**Submission made by Highways England pursuant to Deadline 2 of the Examination of the A30 Chiverton to Carland Cross scheme**

## **Updated Works Plans / Rights of Way and Access Plans**

Sheets 1, 4, 5, 6 and 8 of the **Works Plans** (Document Reference 2.4(B)) and Sheets 1, 4, 5 and 6 of the **Rights of Way and Access Plans** (Document Reference 2.5(B)) have been updated as explained in Appendix A of this letter.

## **Appendix A:** **Overview of changes made to Plans**

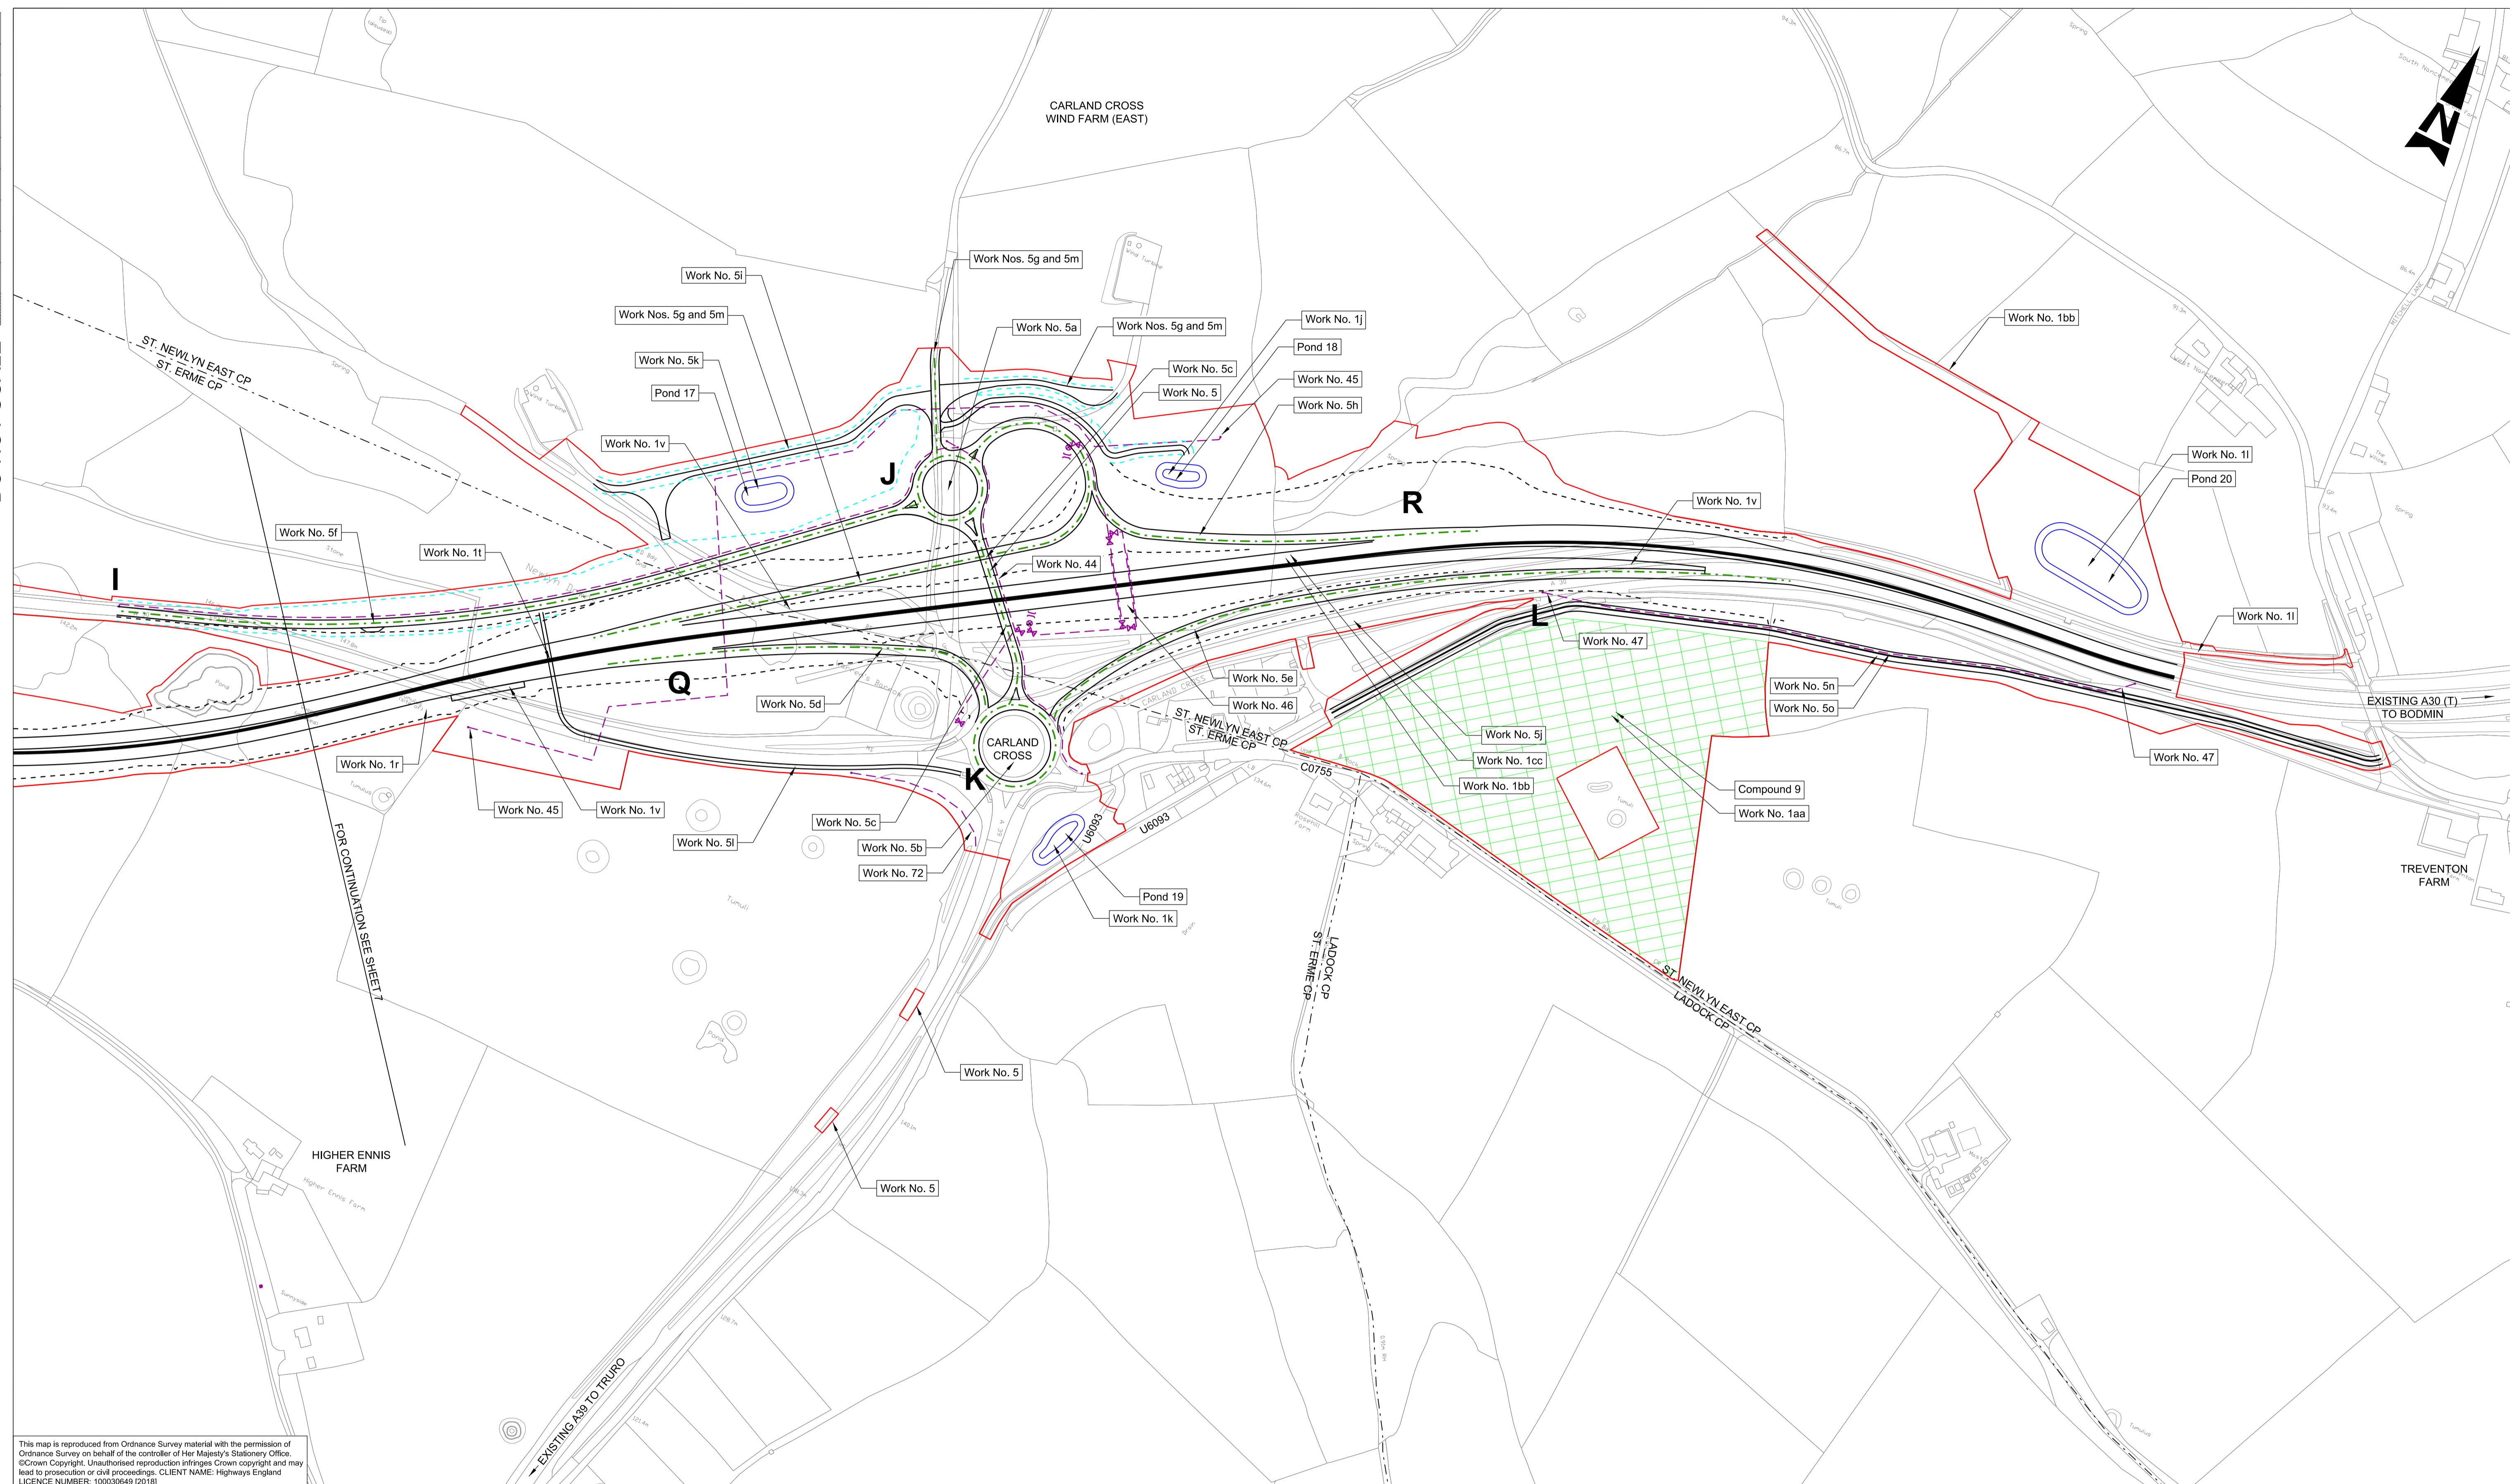
Relevant Plan	Explanation of change(s) made
<b>Works Plans (Document Reference 2.4(B))</b>	
Sheet 1	Work No.3t (Ref 25) amended to be Work No.3r to correspond with the draft DCO
Sheet 4	Leader arrows amended for Work No. 7 Label added for Work No.7a
Sheet 5	Work No. 2j (Ref 12) amended to be Work No. 2i to reflect description in draft DCO BRACKEN WOODS and CHYVERTON LODGE labels added for clarity
Sheet 6	Compound 8 and Work No. 11d label added to correspond with draft DCO Work No.11f Private Means of Access extended to edge of carriageway
Sheet 8	Work No.5(o) added to correspond with draft DCO
<b>Rights of Way and Access Plans (Document Reference 2 5(B))</b>	
Sheet 1	Reference C leader arrows deleted from plan to reflect previous change to draft DCO (Document Reference 3.1(A)) submitted in January 2019
Sheet 4	Legend added

RIGHTS OF WAY AND ACCESS PLANS
APFP REGULATIONS 5(2)(K)
SHEET 5 OF 8

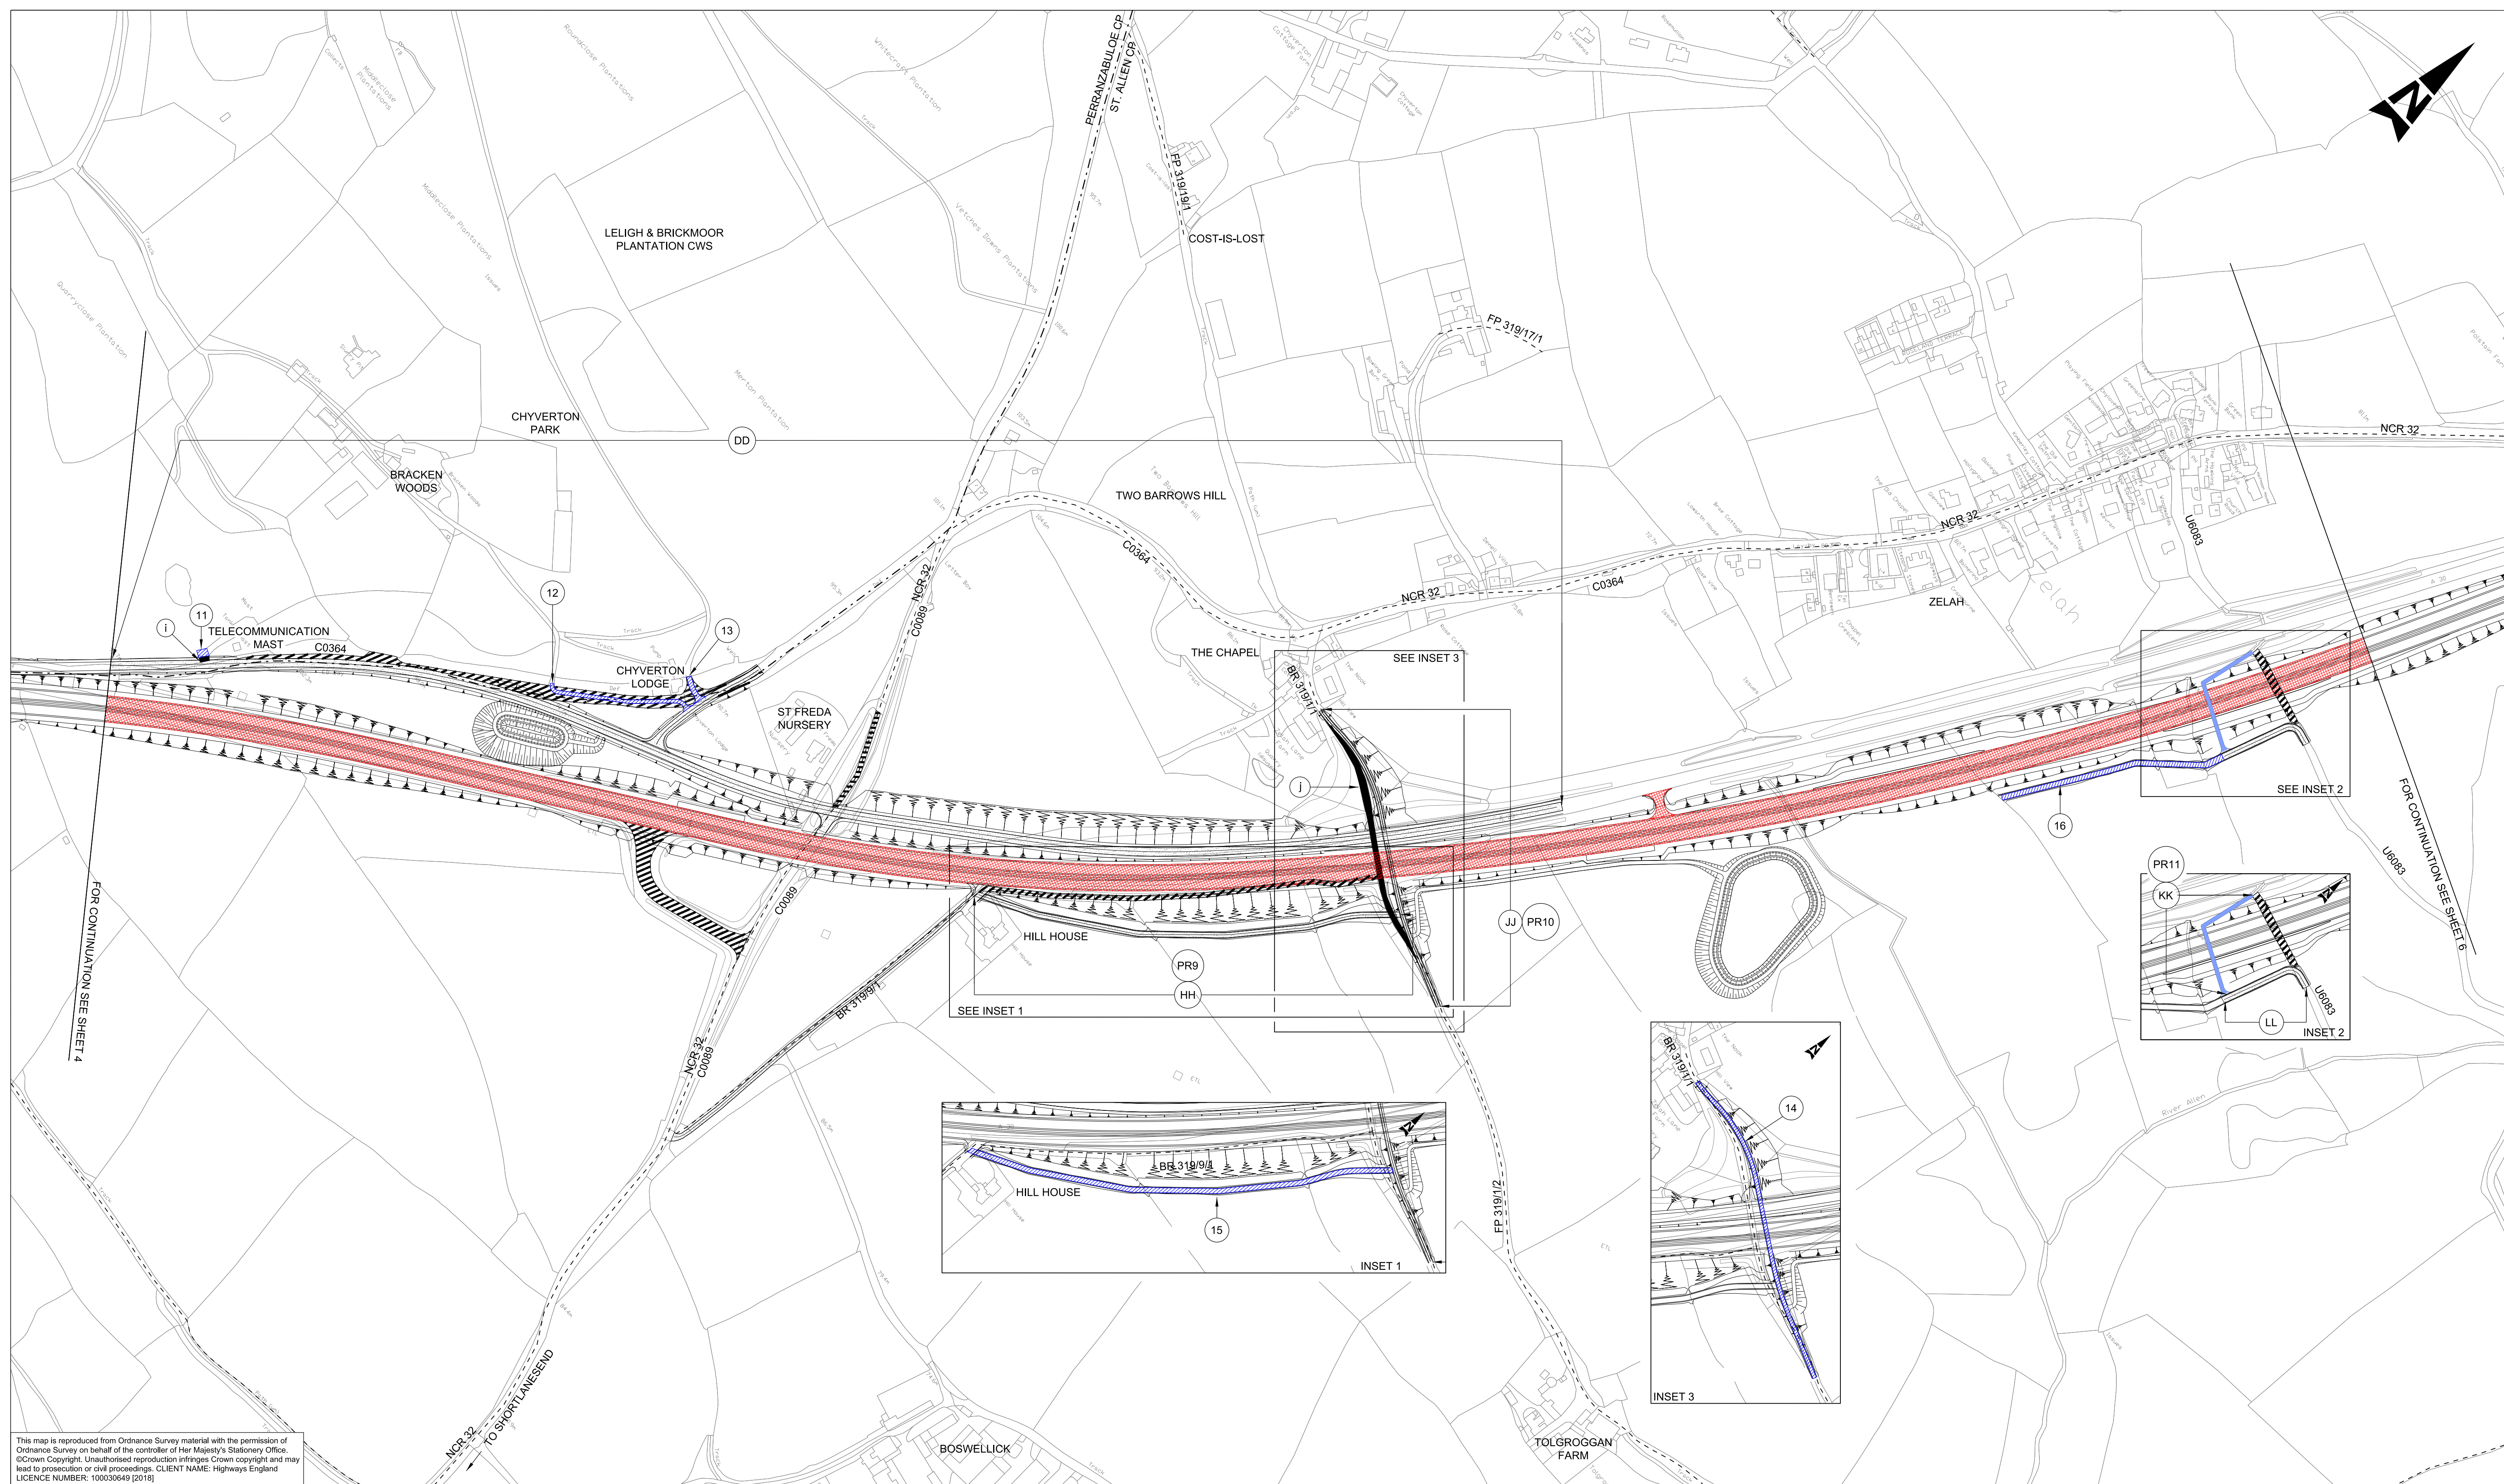
Sheet 5	BRACKEN WOODS label added for clarity Length of Public Rights of Way and Footway / Cycleway deleted to north of St Freda Nursery to reflect previous change to draft DCO (Document Reference 3.1(A)) submitted in January 2019
Sheet 6	Reference 19 length of Private Means of Access extended to edge of carriageway
